DECISION DELEGATED TO HEAD OF PLANNING

Application No: H16-0272-26 **Applicant:** Spalding Energy Company Limited

Proposal: Erection of 3 container units to house emergency generators

Location: Land At Spalding Power Station West Marsh Road Spalding

SPALDING POWER STATION
CONTAINER/GENSET

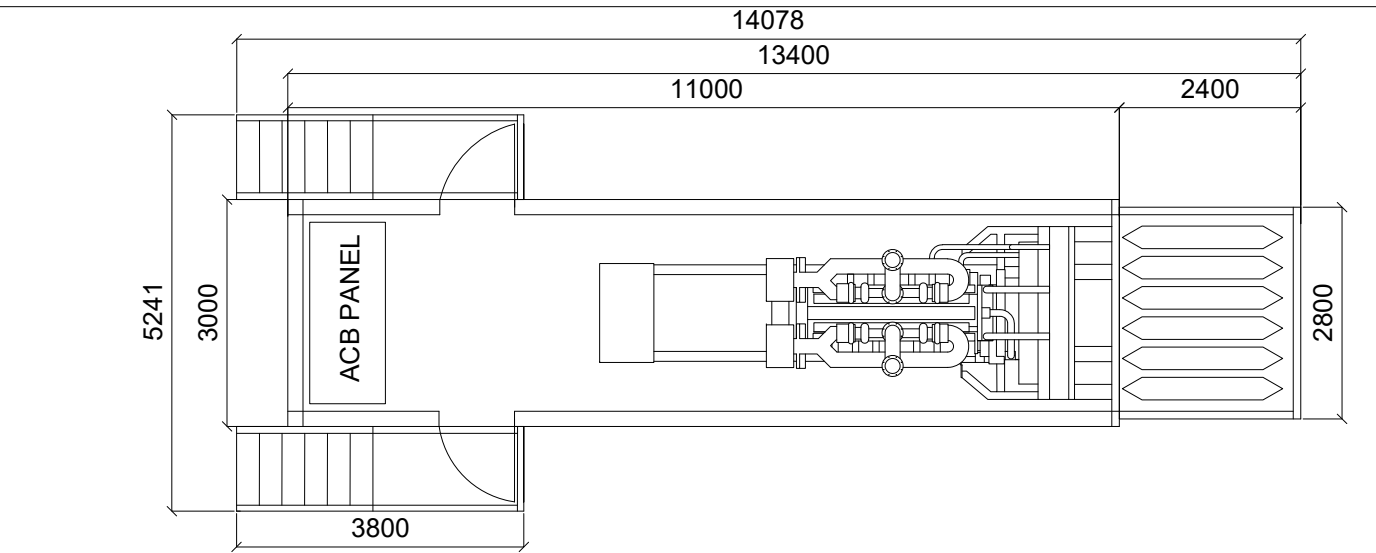
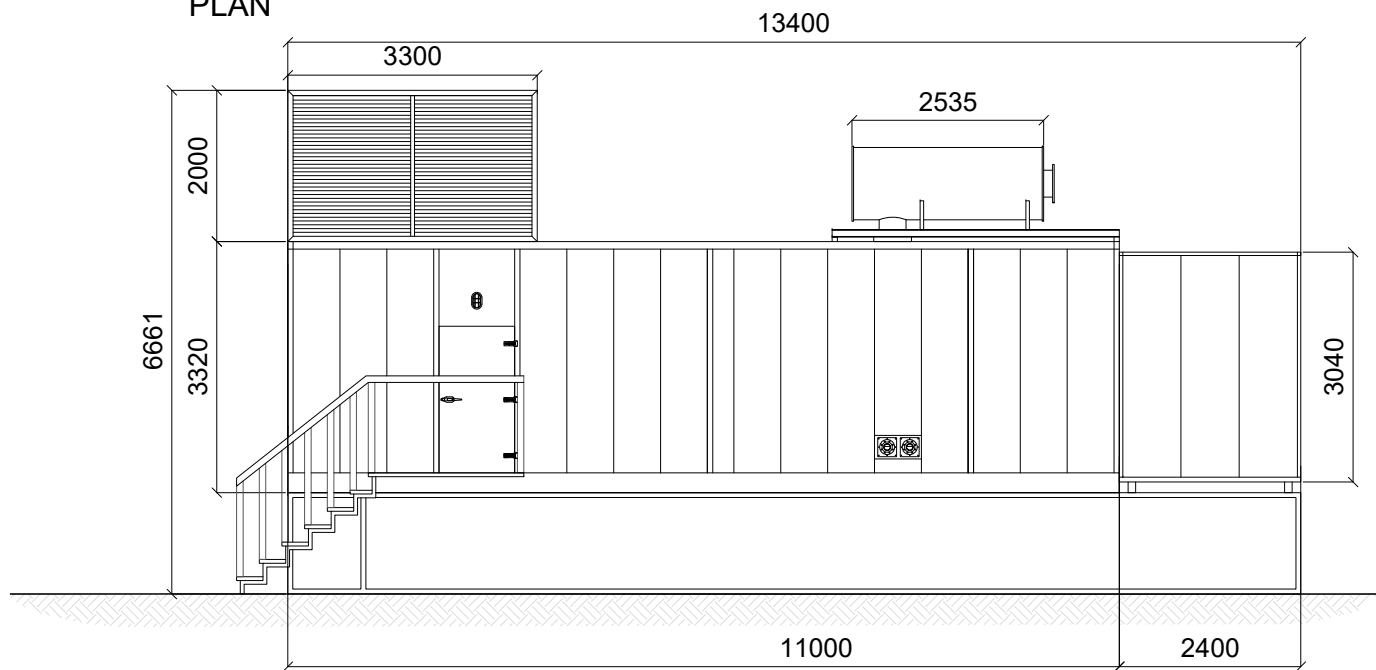
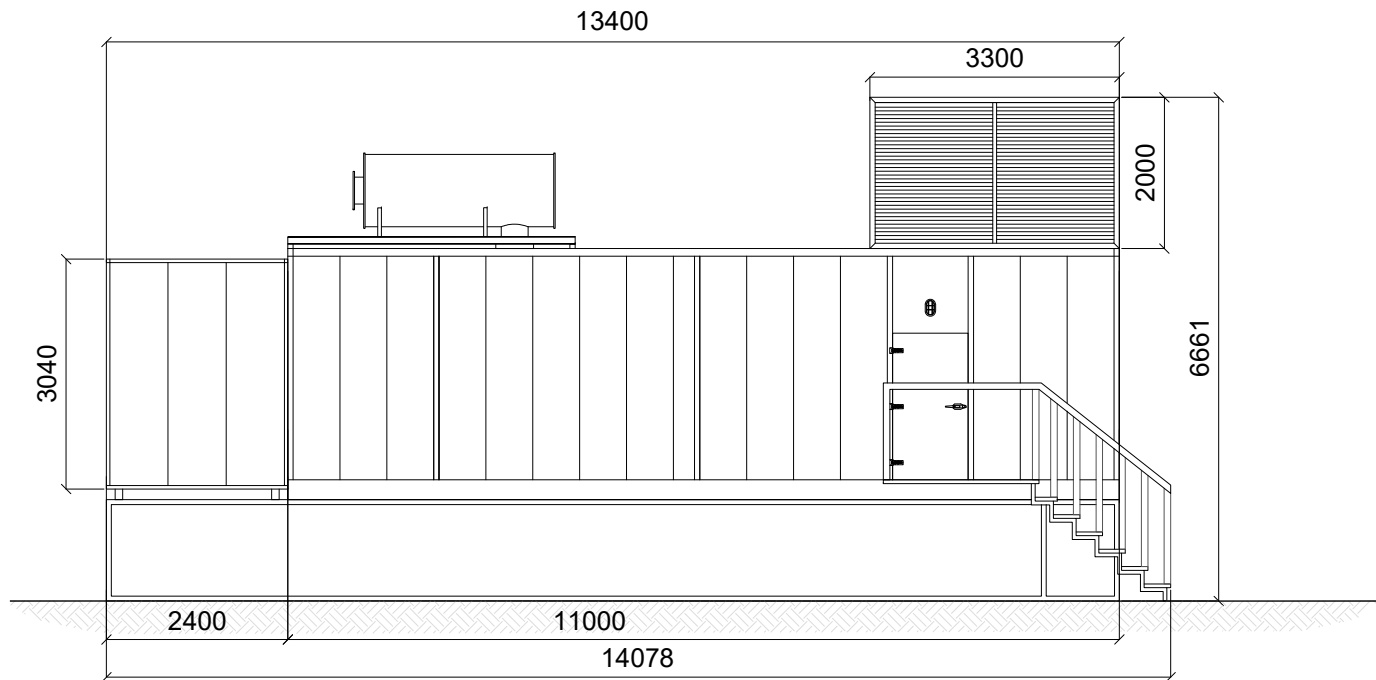
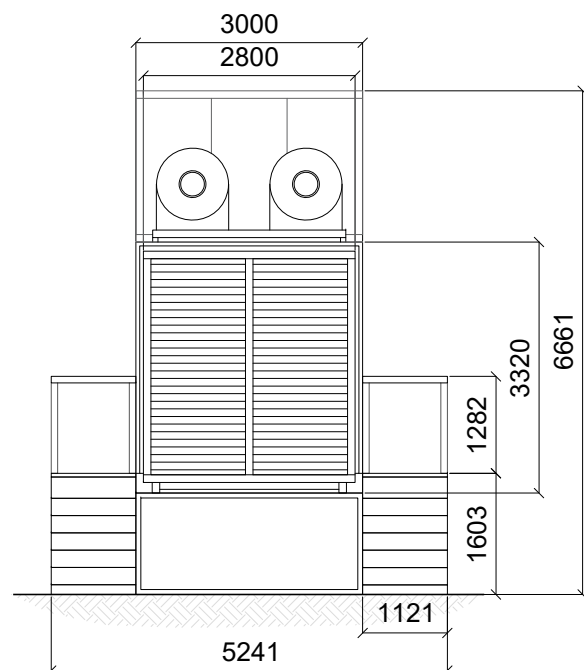
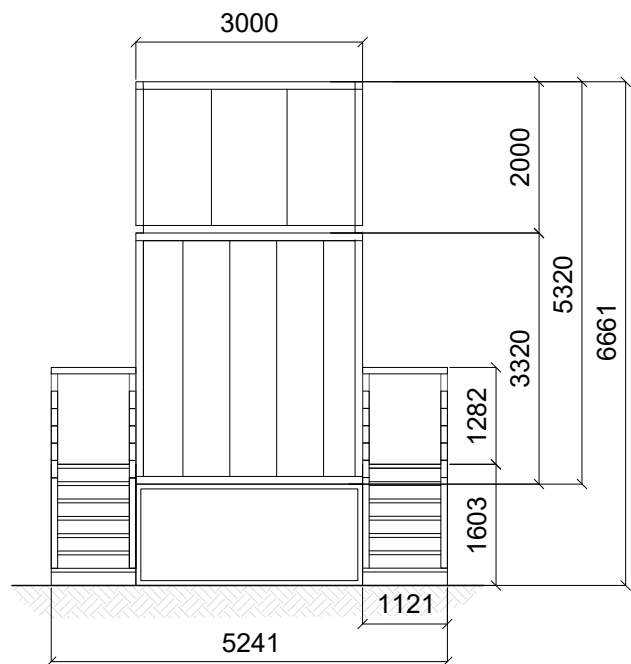
We have no objection to the application as submitted. The site could be affected by depths of up to 1.6 metres. The drawing 'Spalding Power Station Container/Genset', drawing number 'SD01-03' shows the container units will be set 1.6 metres above ground level, therefore will be resilient to flooding.
